Date: 19th May 2021

**Re: Erection of Two Storey Side Extension, Single Storey Front/Rear Extension &
Rendering of the Existing Dwelling**
Address: 18 Mardale Road, Dewsbury, WF12 7NS
Your Ref: 2021/91641

Client:-	
Mr & Mrs Williams	
Location:-	
18 Mandale Road, Dewsbury, WF12 7NS	
Drawing Description:-	
Proposed Floor Plans and Elevations	
Scale:-	
1:50	
Scheme:-	
Two storey side extension, single storey rear extension and loft conversion	
Drawg Number:-	
PI-02	
Date:-	
Mar 21	
Author/Name:-

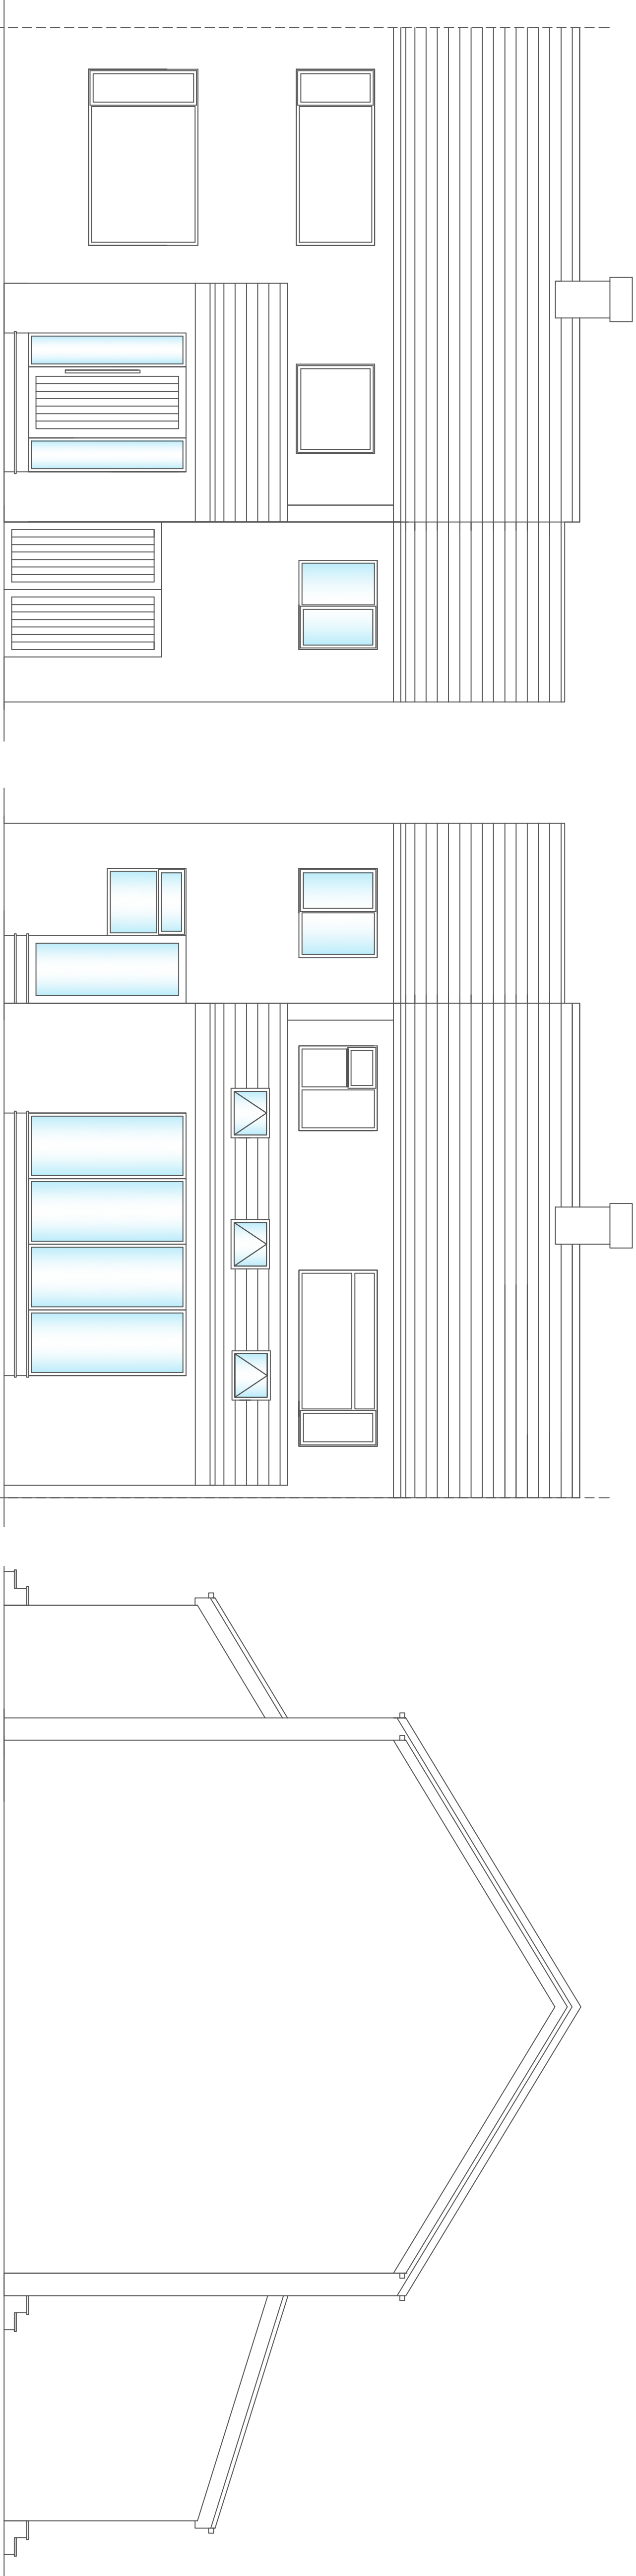
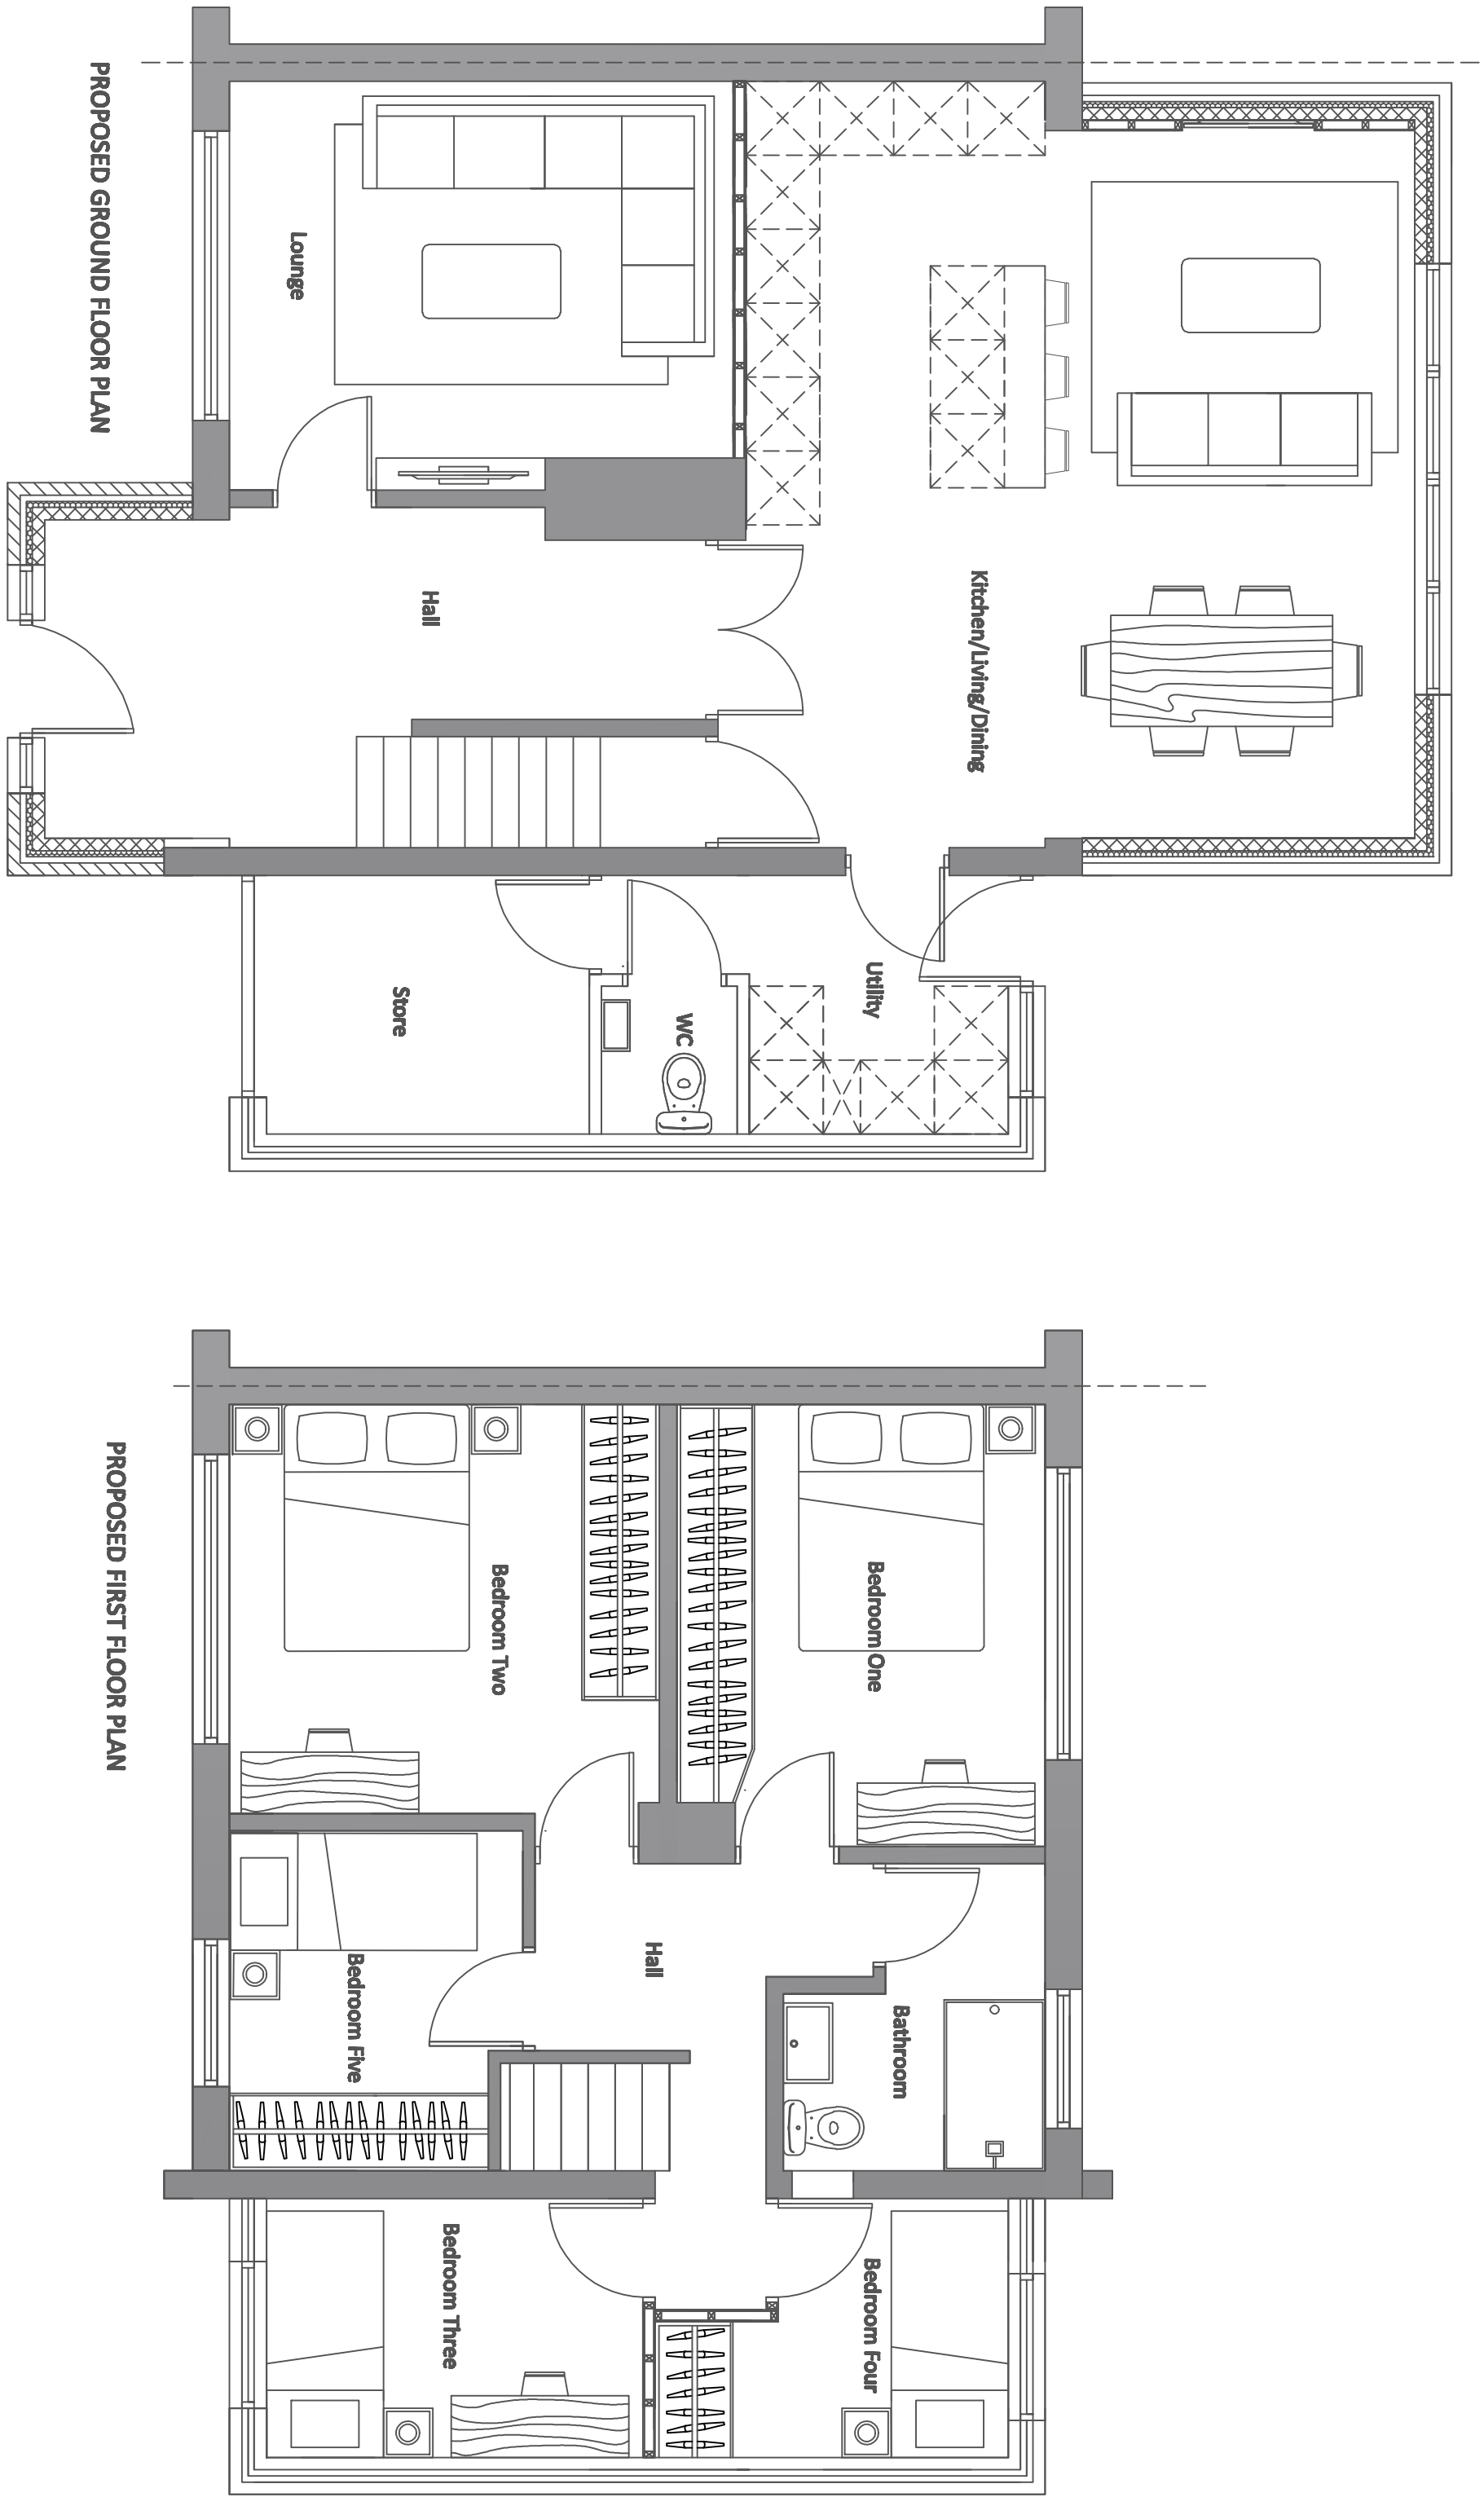
Having reviewed the planning application drawings, the double storey side extension as shown is to be built up to the shared boundary and with no form of set back from the main front elevation and lower roofline which will create a negative impact to the street scene.

The other concerns are the drainage including the gutter overhang and rain water/waste pipe positions to the side extension which usually projects out from the external wall and may end up in our land.

The proposal has been described to be rendered which in our opinion will not fit in well within the surroundings as the properties are generally brick built. To build the side extension no doubt access for scaffolding will be required on the neighbouring driveway/land of number 16 Mardale Road, and to date no form of party wall agreement has been put in place to ensure no damage is caused to No. 16 Mardale Road during the construction process.

No site plans have been submitted with this application to show the existing and proposed layouts and the plans in general although scaled do not confirm any dimensions of the proposed extensions itself.

Taking the above points raised into consideration and before this application is decided further information is required to determine the exact location of the double storey side extension including distances from the shared boundary line.
